WISWELL PARISH COUNCIL

3rd October 2012

Planning Application No: 3/2012/0802
Proposed demolition of existing garage and stable buildings and replacement with garage building linked to house via glazed porch (re-submission)
Pepper Hill, Pendleton Road, Wiswell, Lancashire, BB7 9BZ

4206 - 10 D

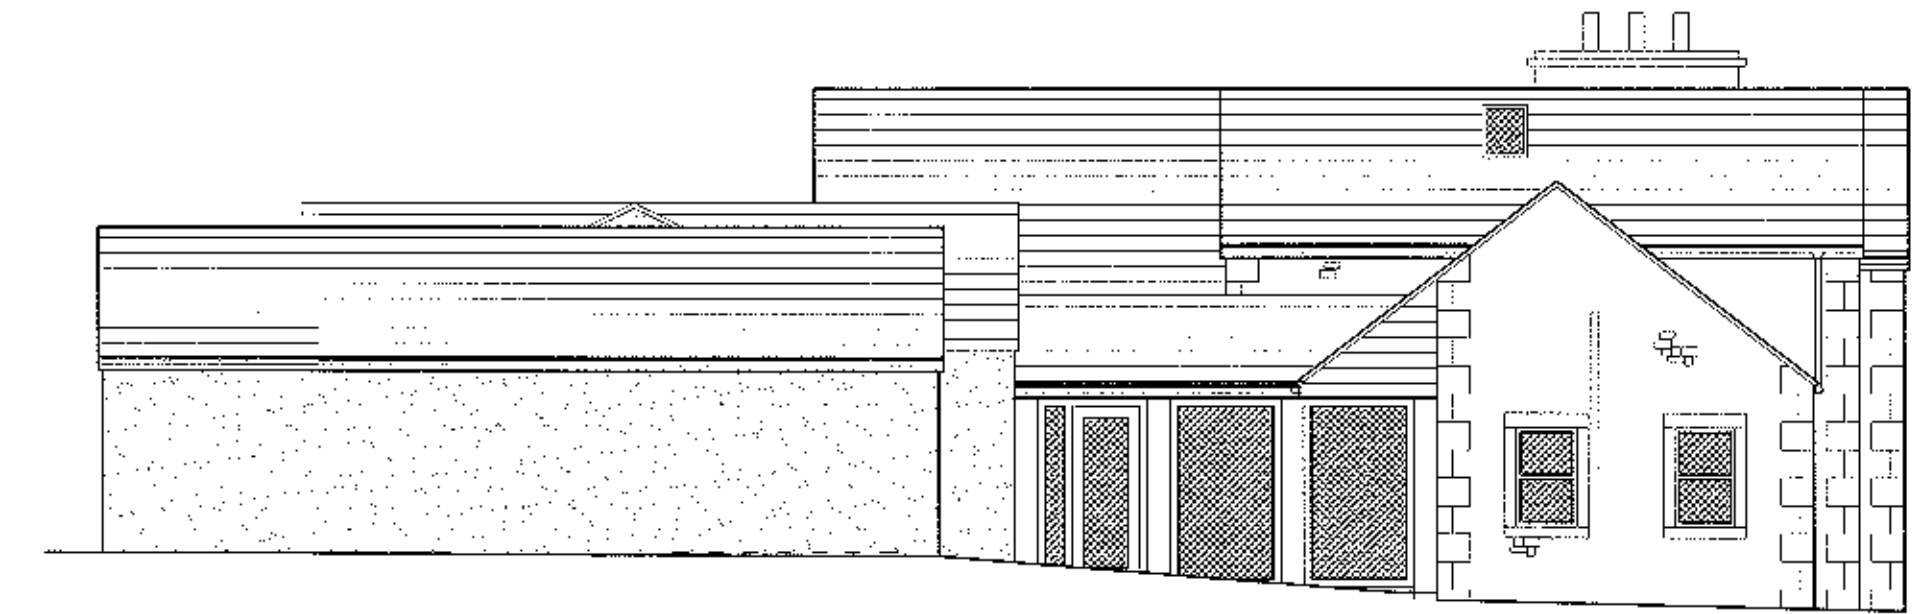
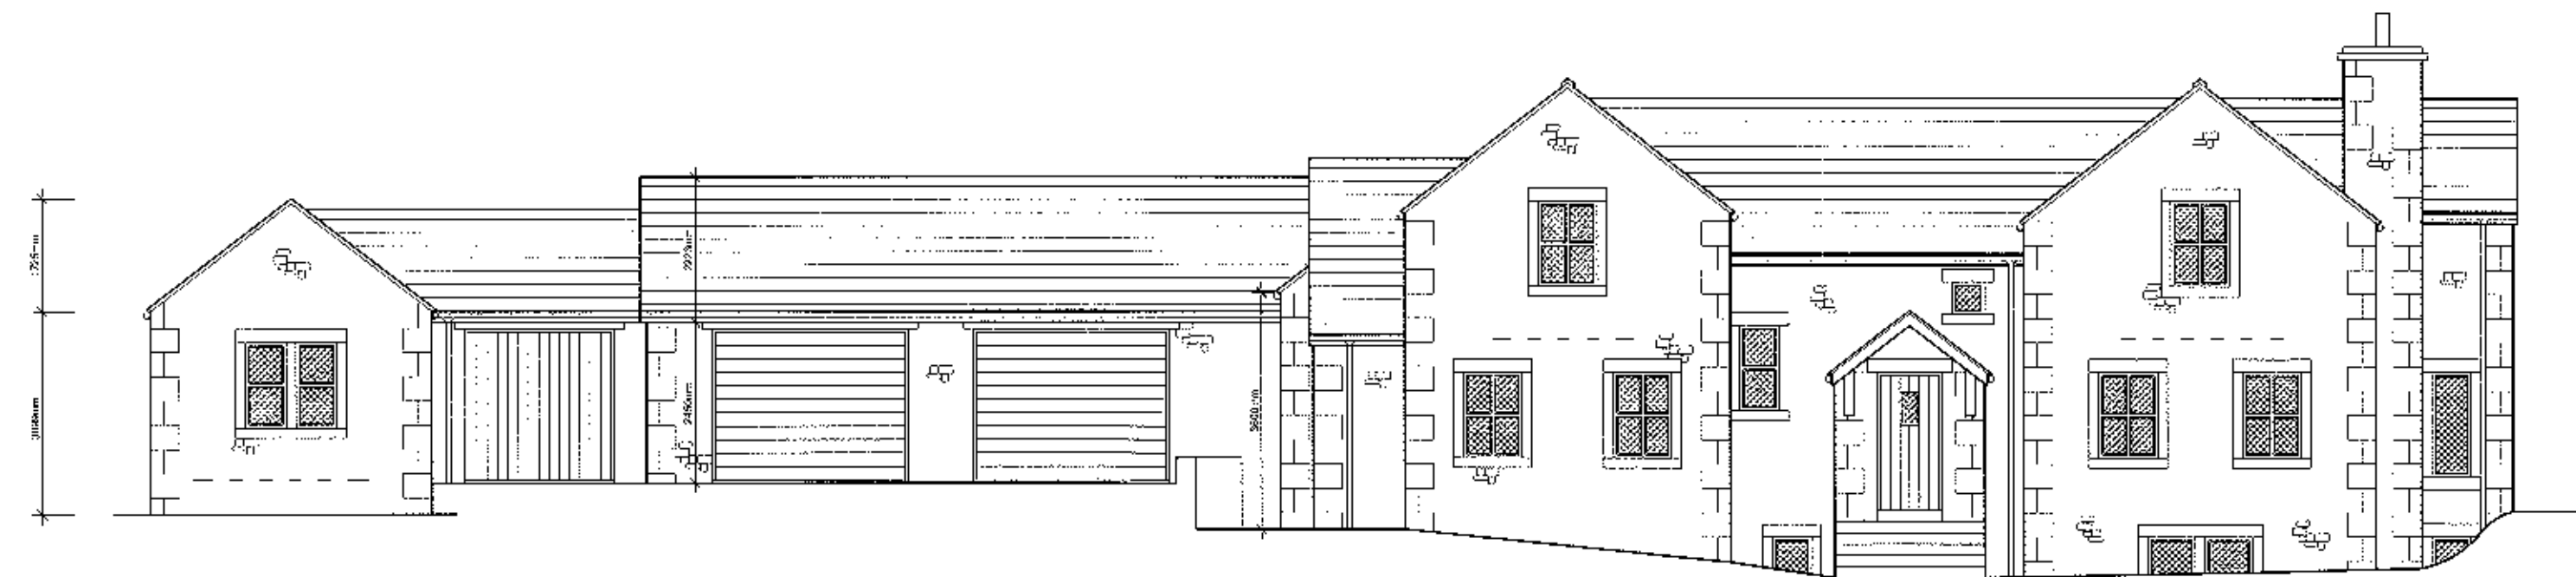
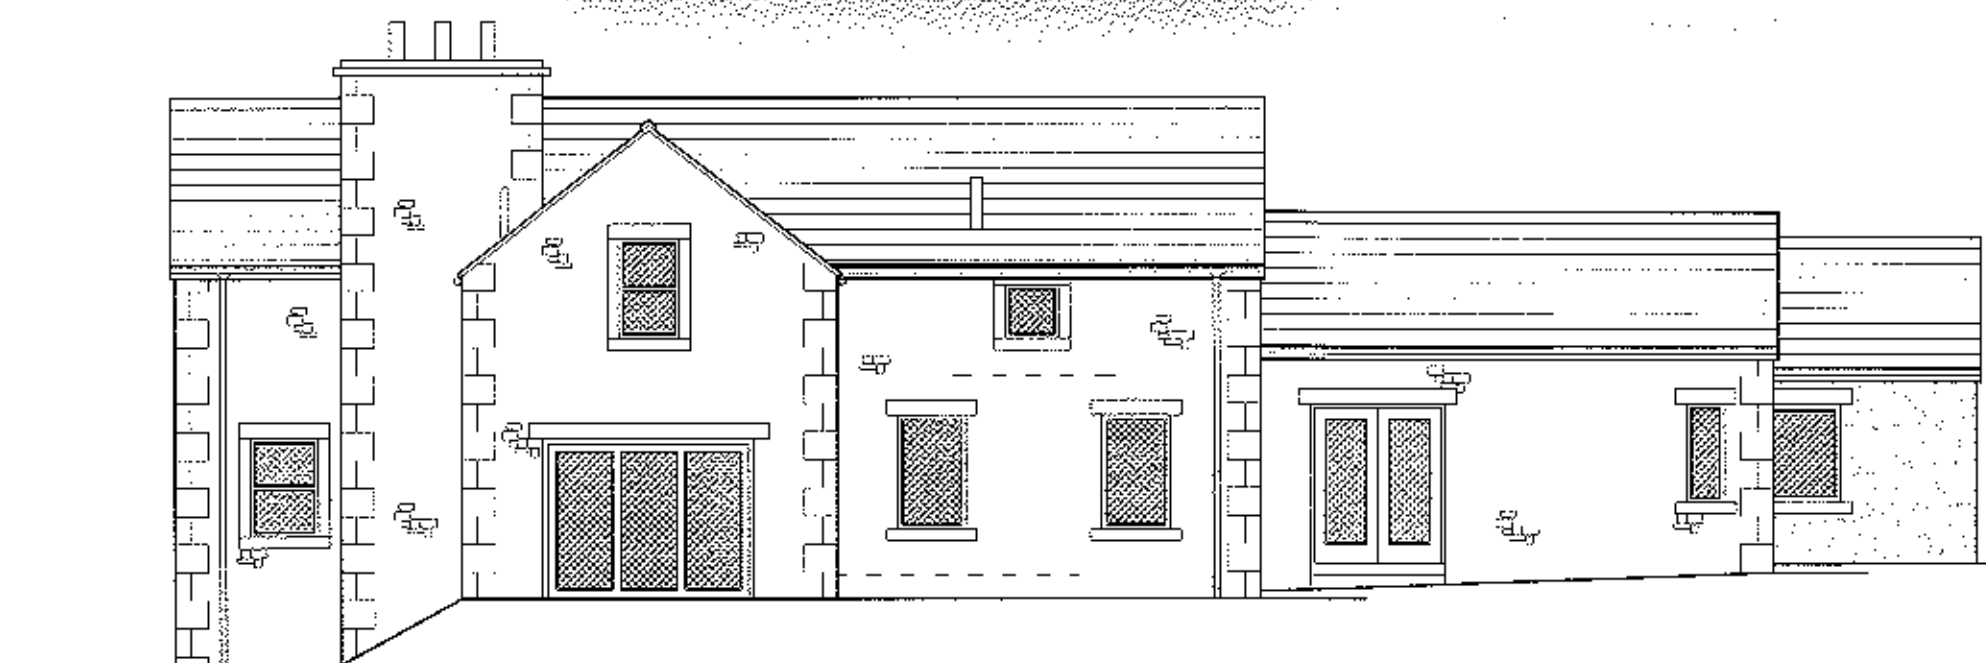
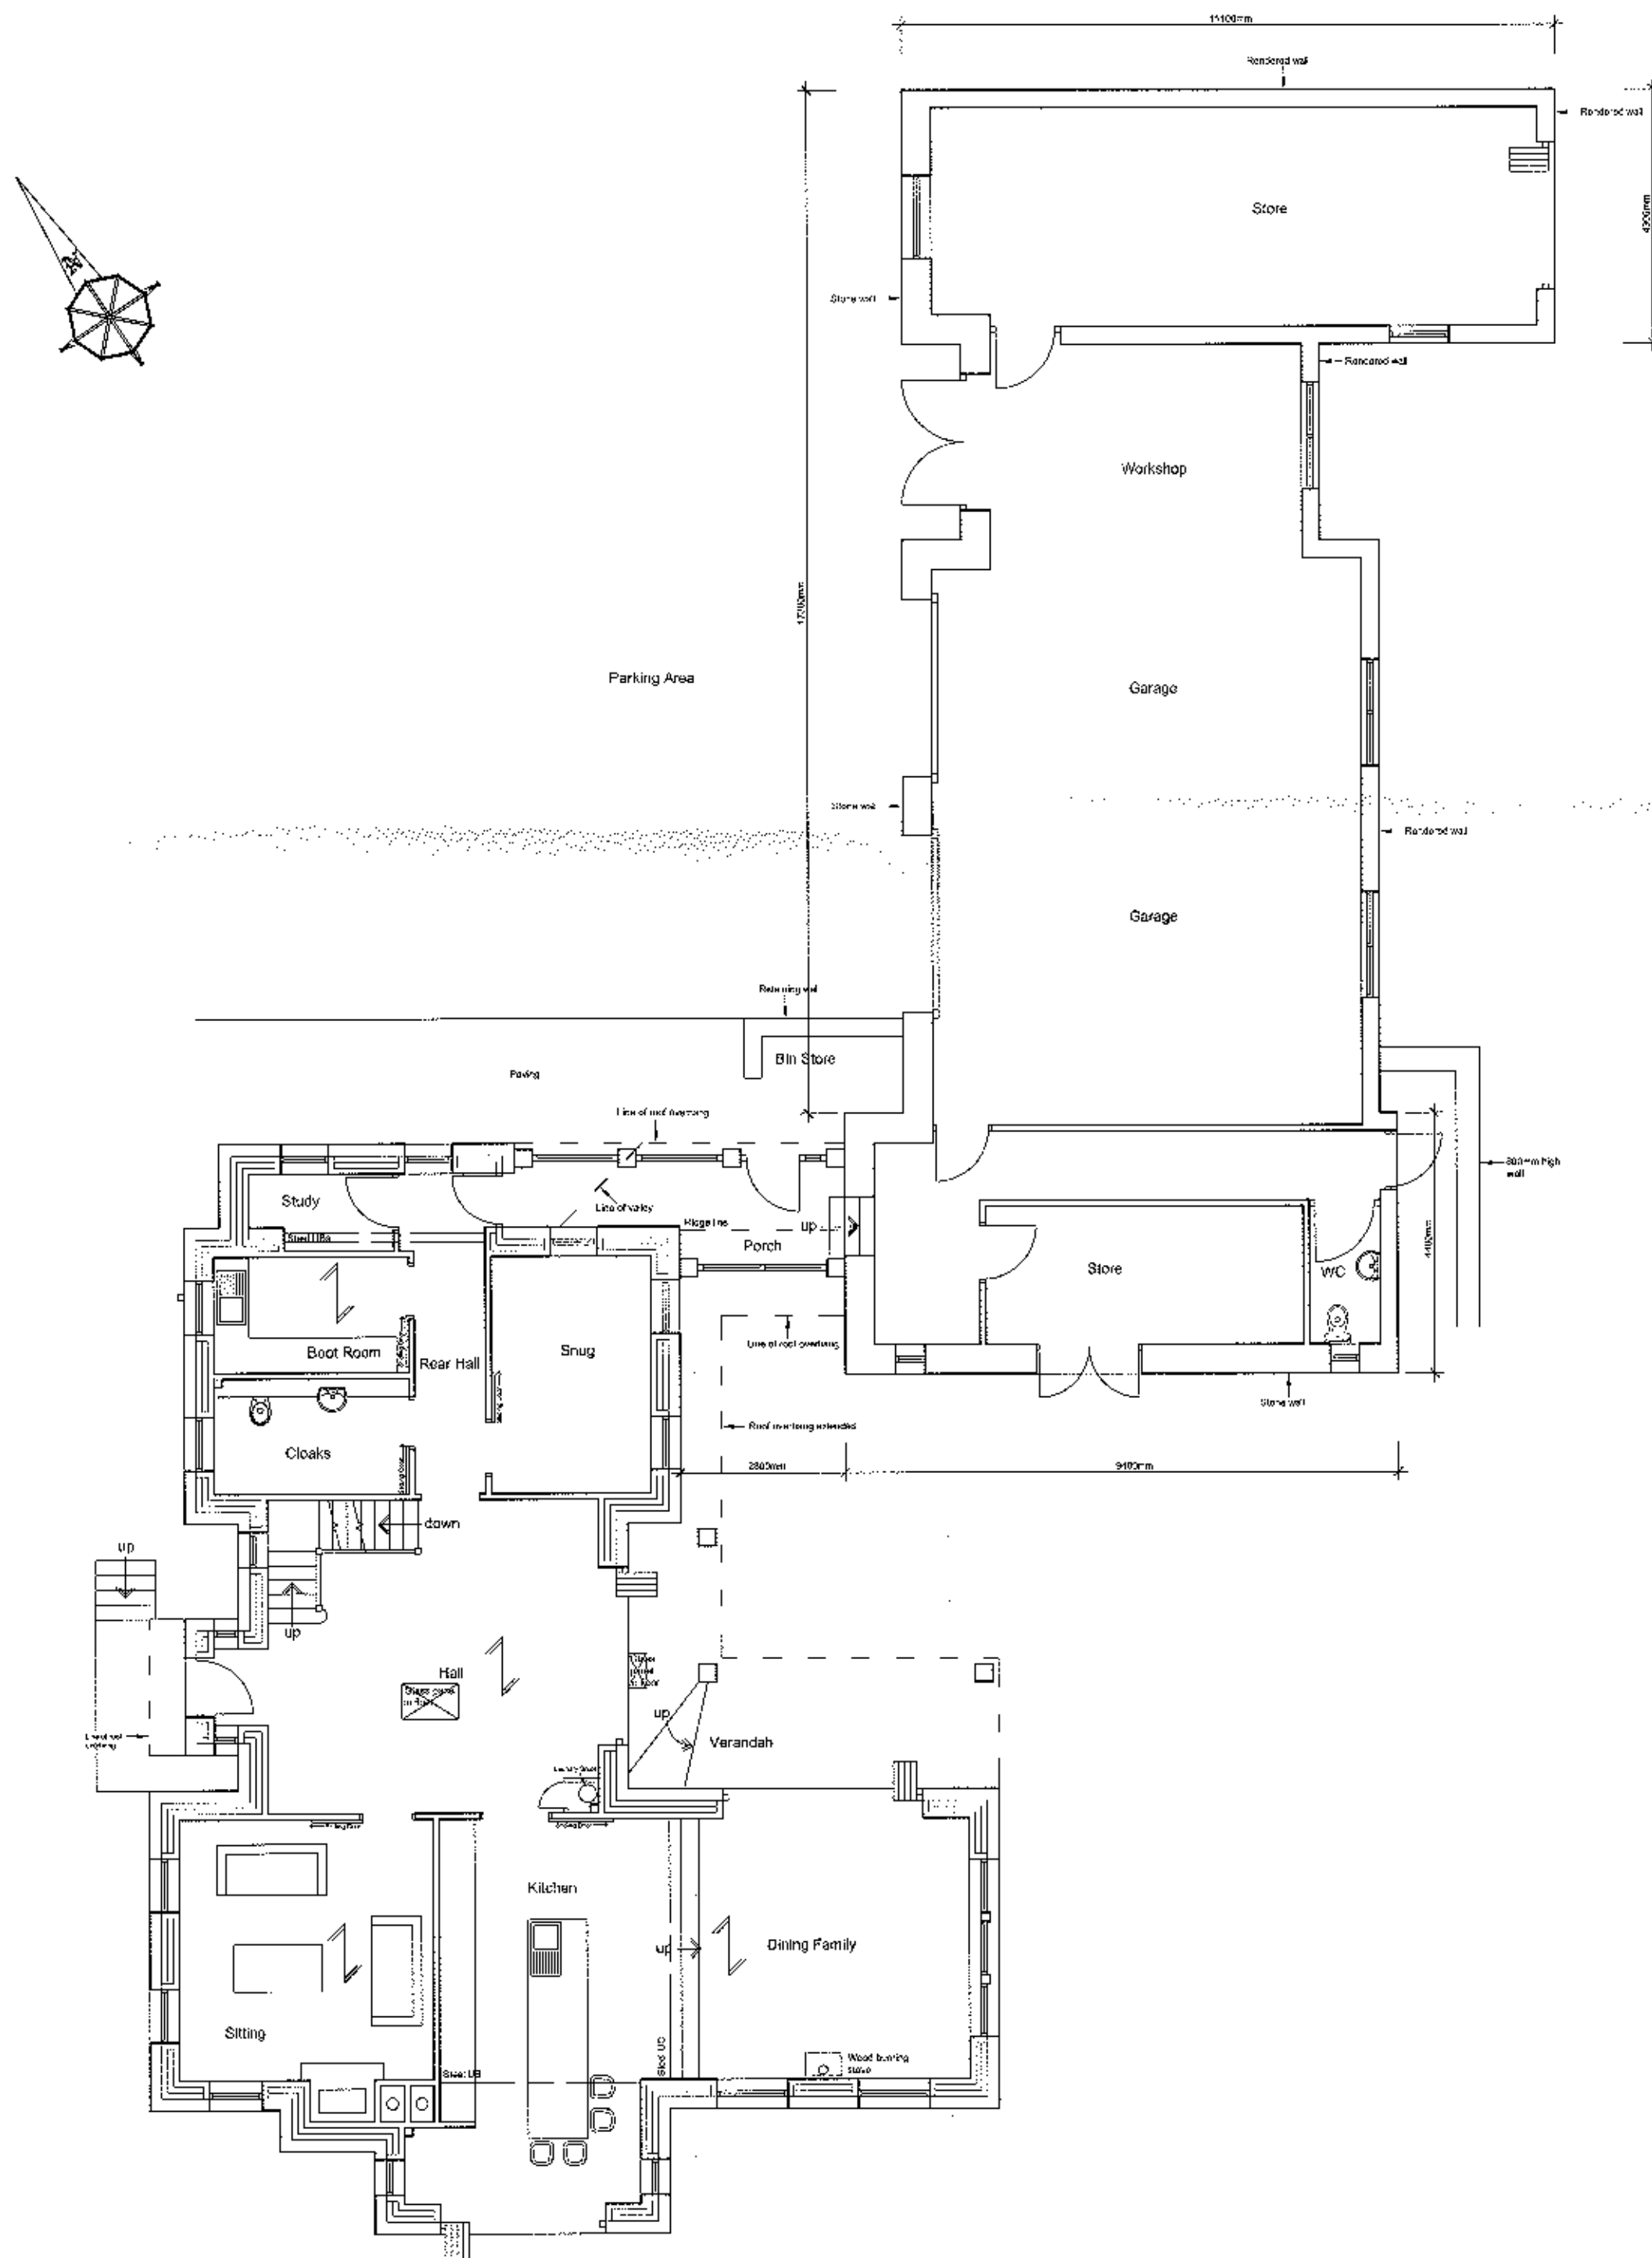
The above application has now been considered by the Parish Council. Members have observed that the length of the garage and ancillary building on the east side is disproportionate to the approved replacement dwelling and they consider this detrimental to the rural street scene. Members have also commented that the proposed store does appear to have the potential to be a granny-annex in the future.
